Planning & Regulatory.S Masia  
Reference: ECM5435004  
Phone: 02 4974 2054

14 February 2018

**DAN LAND SUBDIVISION CONCEPT AND PROJECT APPROVAL (MP06\_0031 - MOD4)**

Figure 2: Indicative Lot Typologies Plan

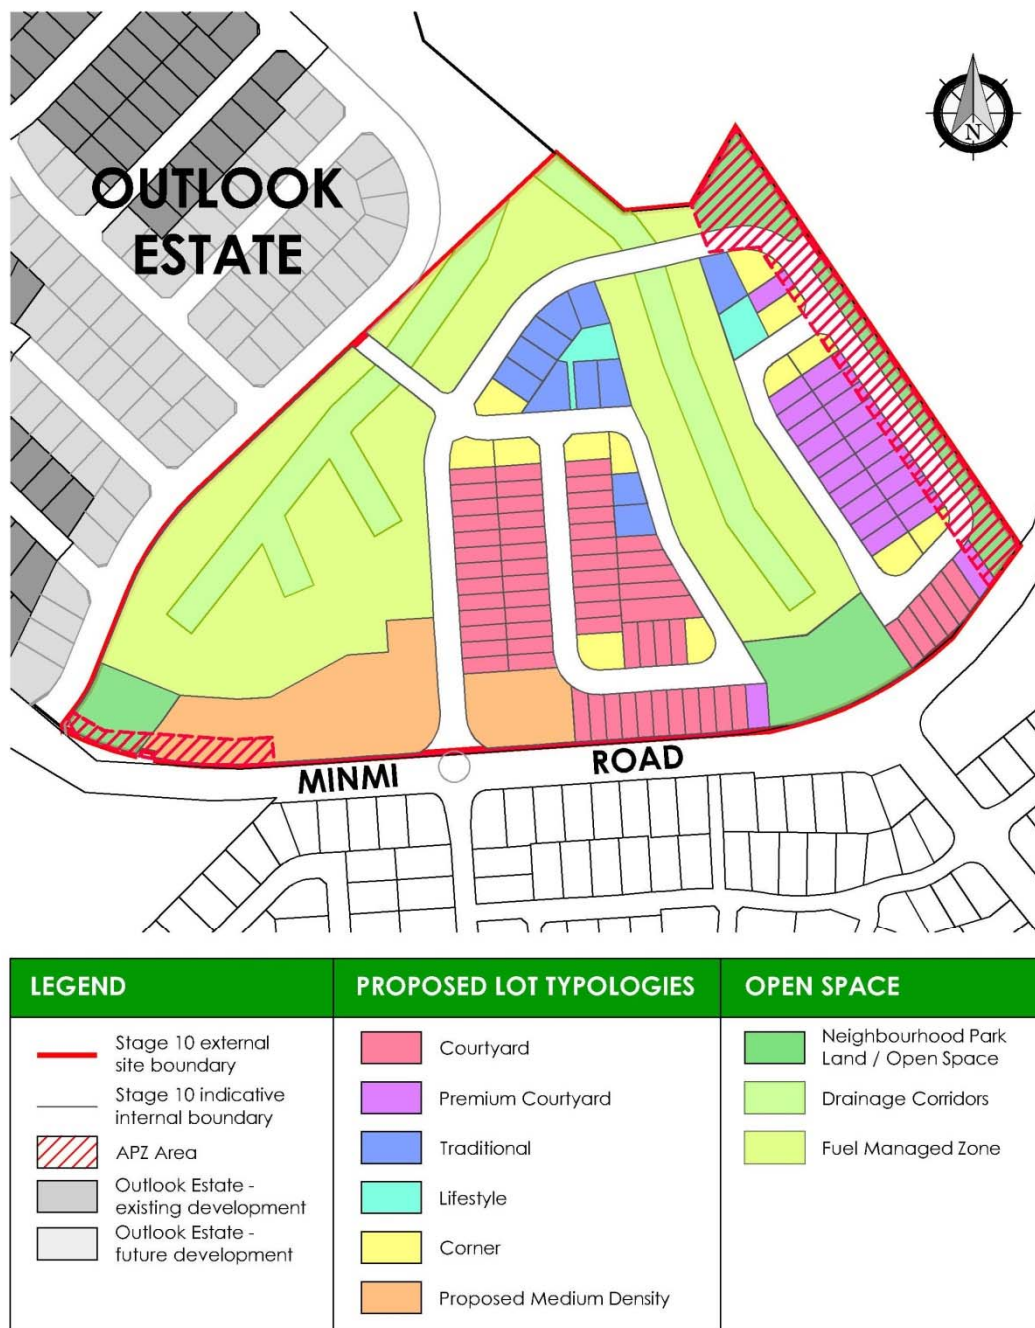
- Table 1 - Note 4 appears to be redundant given there is no controls in Table 1 relating to battleaxe allotments, as Figure 2 identifies the battleaxe lot as a 'lifestyle' lot.
- 2.4.2 Controls - Private Open Space. Control 1 should not refer to Element 7.02 Landscape Open Space and Visual Amenity as this section of the Newcastle DCP 2012 does not contain provisions for private open space. Instead Control 1 should read:

site details:  
MINMI ROAD, FLETCHER  
client:  
NORTHWEST RESIDENTIAL  
date:  
04.04.2018  
job number:  
9496.5  
scale:  
1-2000 @ A3  
drawn:  
SGK / RDS / KM  
rev. number:  
G

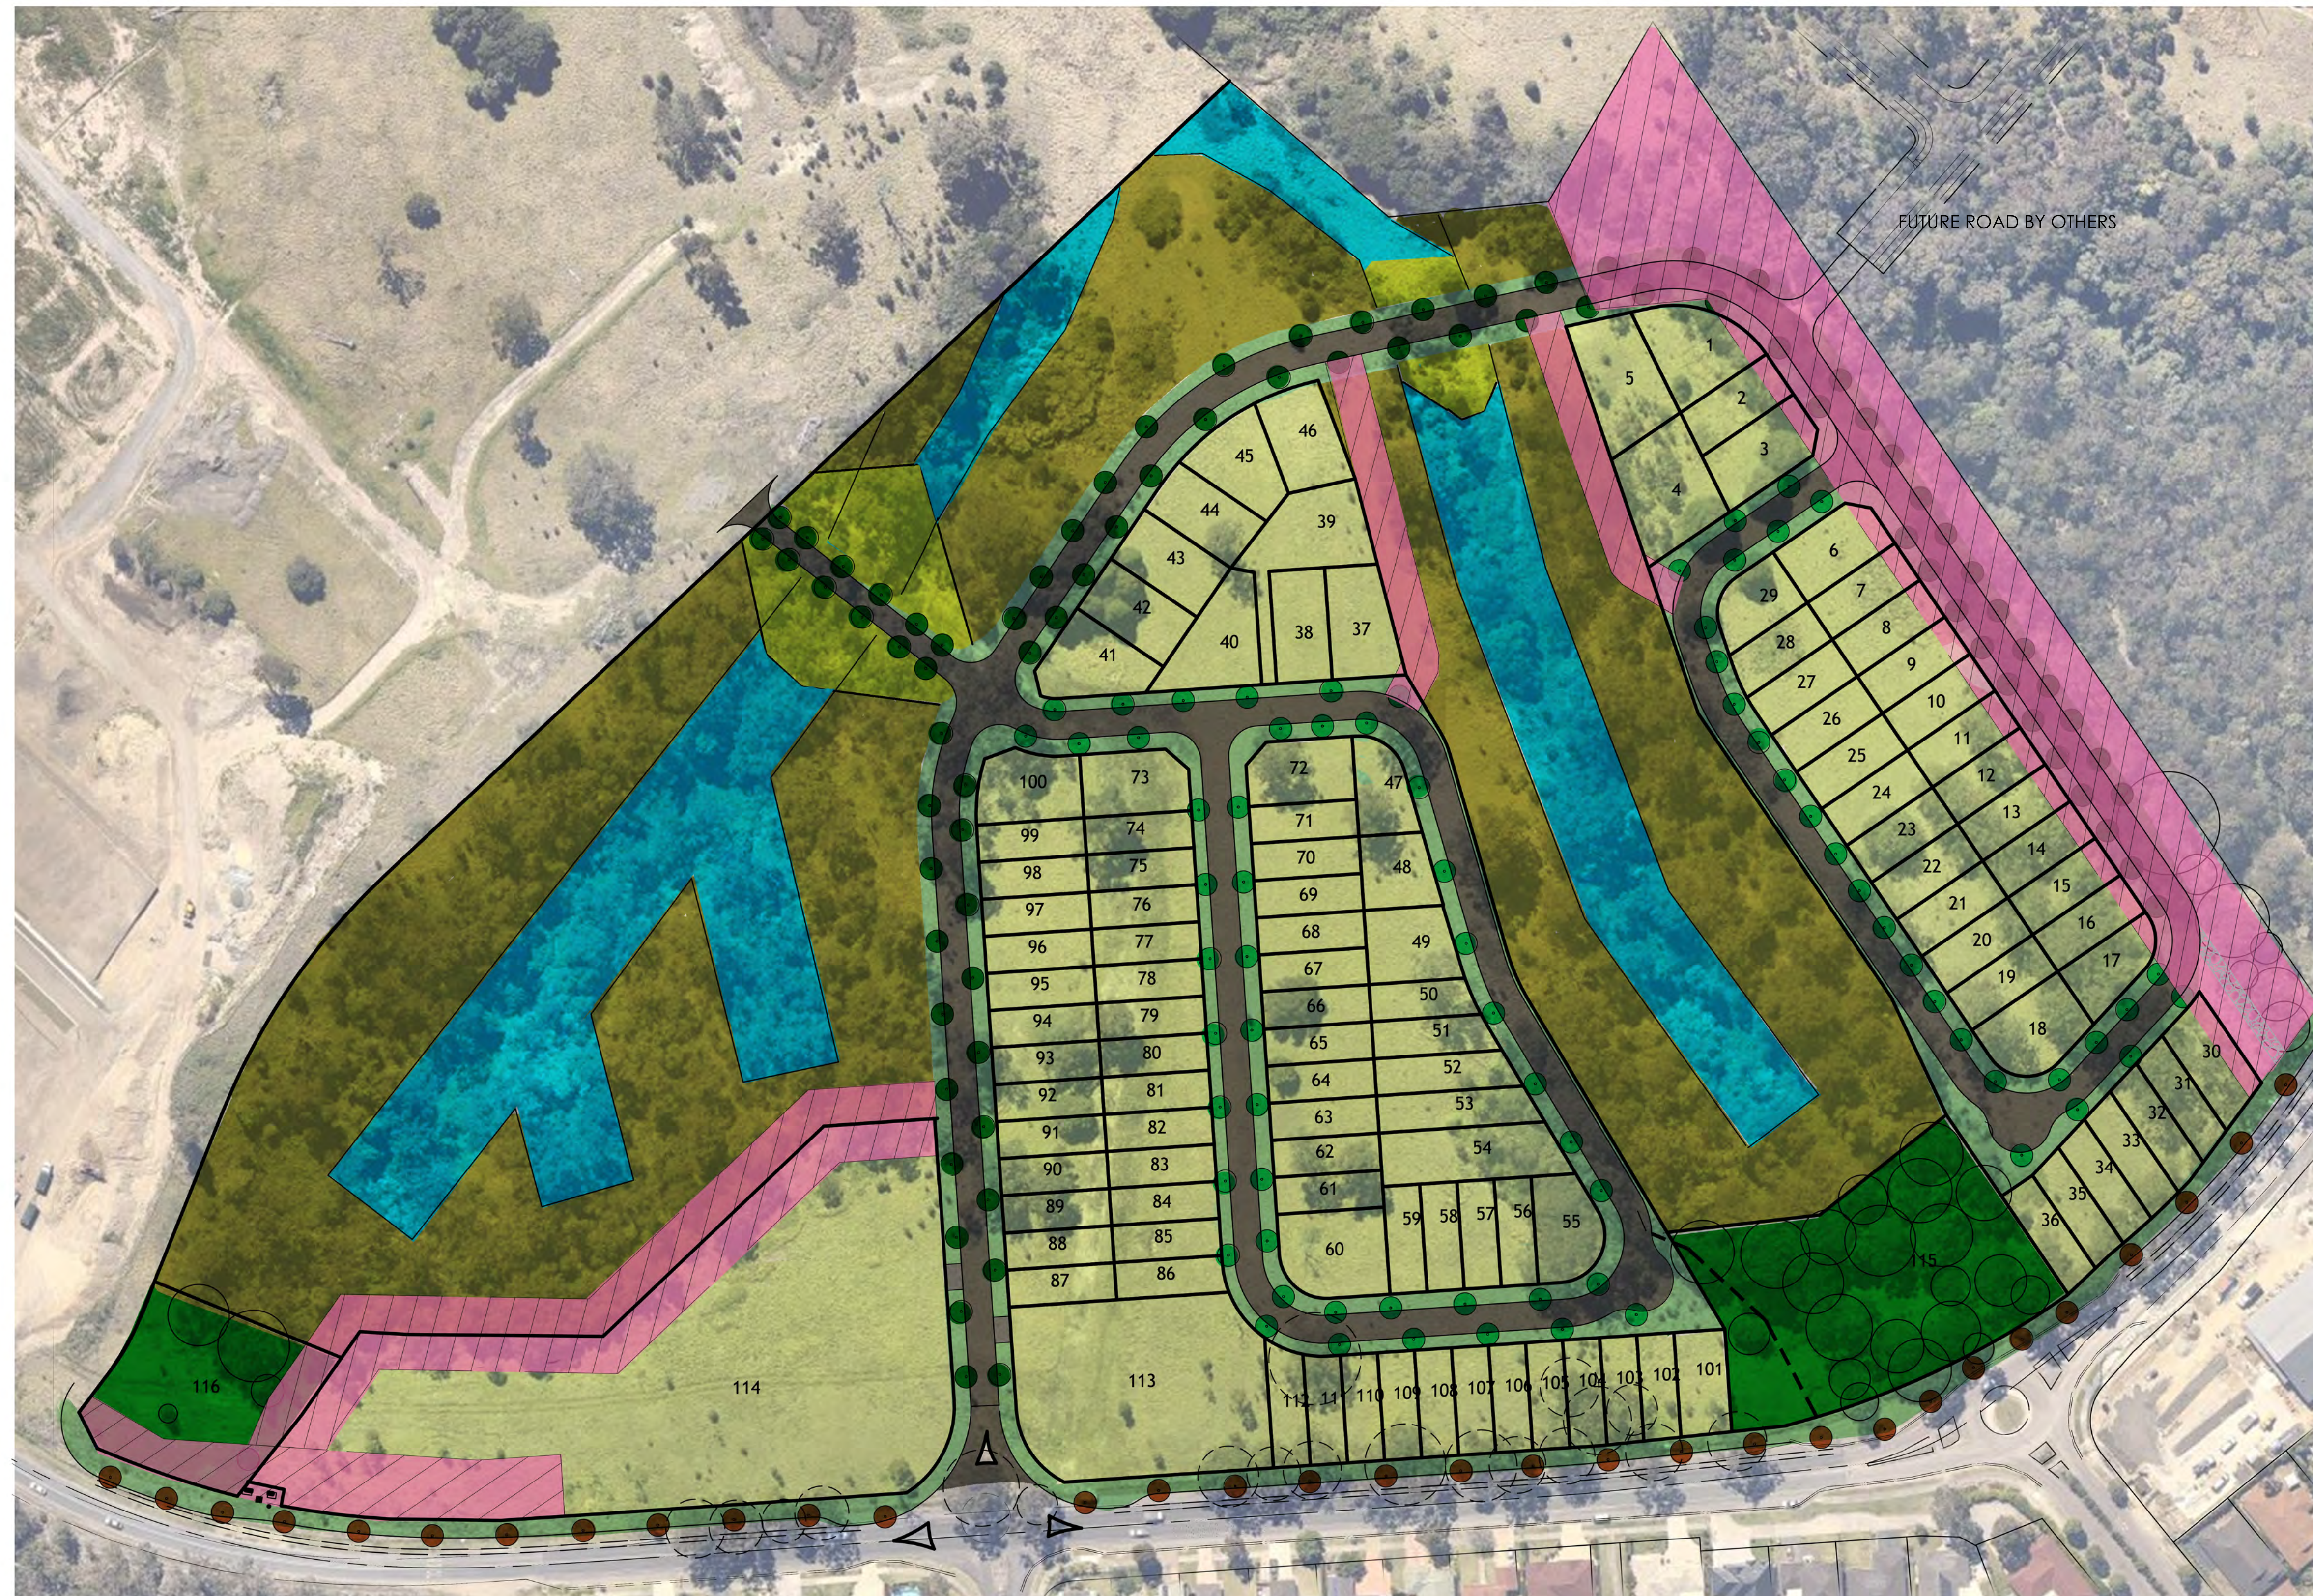
- **Additional condition - Landscape Masterplan** - Given that there are no driveways proposed to/from Minmi Rd to the proposed lots adjacent Minmi Rd then there is no restriction on the spacing for street trees within the Minmi Road footway. Accordingly, to help offset the loss of all of the significant trees along this length of Minmi Road and to aid in mitigating the physical appearance of continuous fencing it is considered appropriate that the Landscape Master Plan provide for street trees at a generally at a maximum of 10m centres.

*An amended Landscape Masterplan, showing street trees along Minmi Road to be planted at a typical spacing of 10m centres in accordance with Council's requirements, shall be submitted to the satisfaction of the PCA prior to the issue of a Construction Certificate for Stage 10.*
